PORTLAND MAINE

January 21, 2009

Re: 16 Whitehead Street, Peaks Island – 084 N004 – IR-2 – permit #09-0028

PLOT PLAN

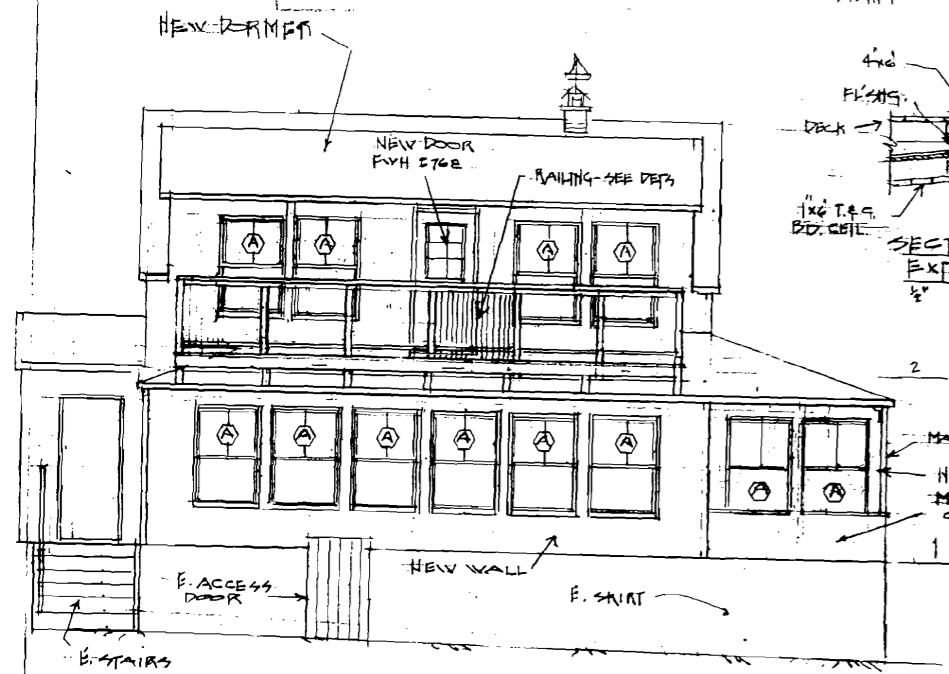
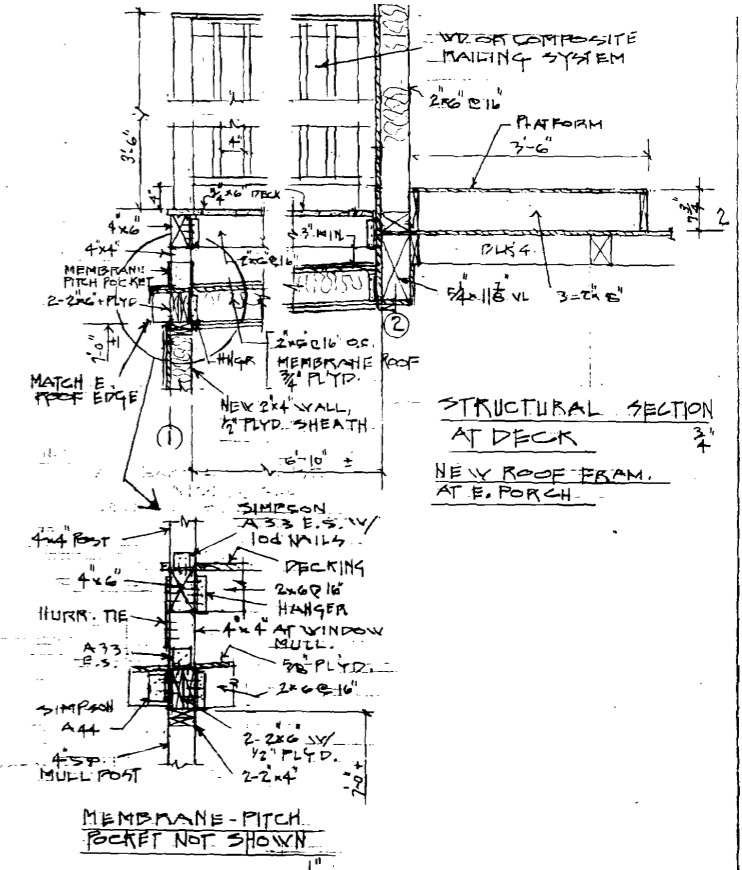
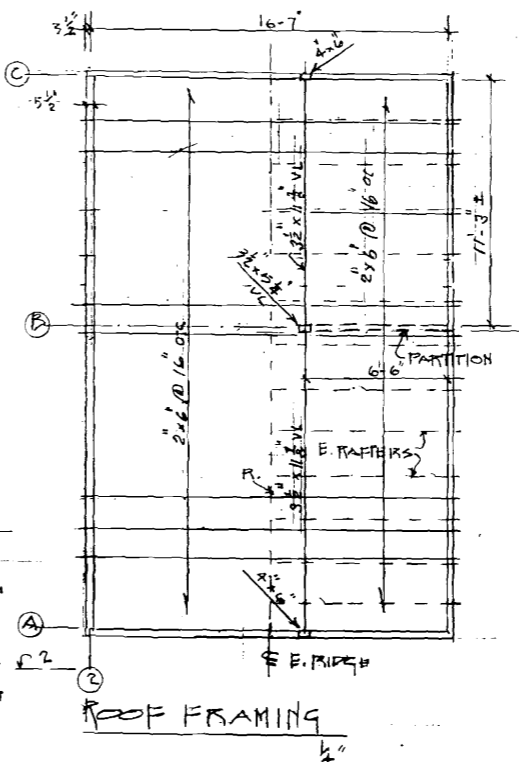
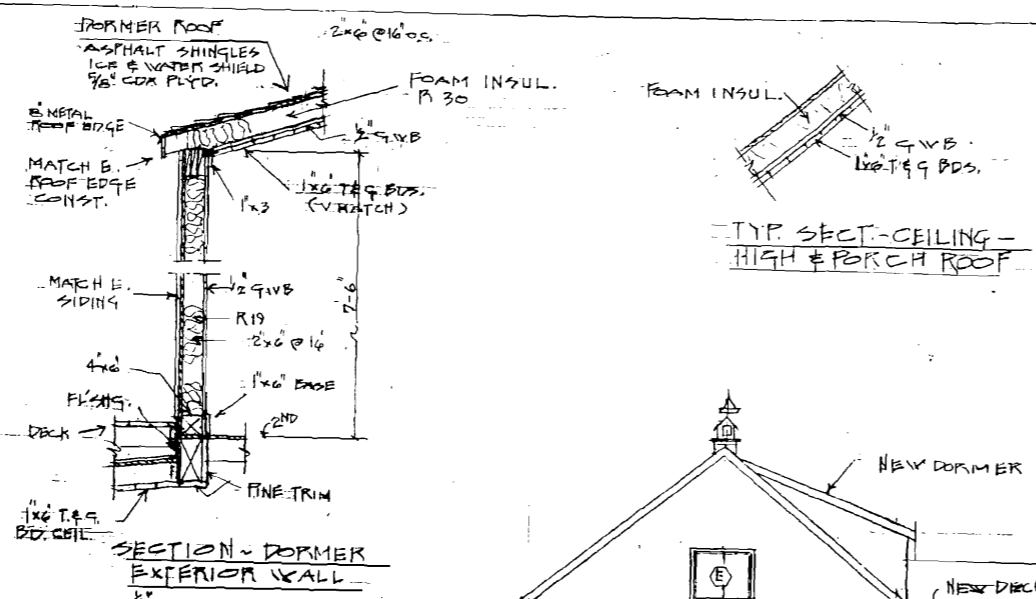
16 Whitehead Street, Peaks Island is located in the IR-2 residential zone. Section 14-145.11(c) of the ordinance gives the minimum required side setback as twenty feet. The plot plan submitted with the application shows the side setback to the six foot by eight foot room as eleven feet. Section 14-145.11(d) gives the maximum lot coverage as twenty percent of the lot. The lot is 4,109 square feet, so the maximum lot coverage is 821.8 square feet. The footprint of the building that existed on the 1951 assessor's card is 1,054 square feet which is already over the allowable maximum lot coverage. The six foot by eight foot addition makes the building more nonconforming. Since the six foot by eight foot room does not meet the side setback or the maximum lot coverage, it cannot be permitted under today's standards. Unless you can find a record of a building permit for the six foot by eight foot room, you will need to remove it to bring the property into compliance.
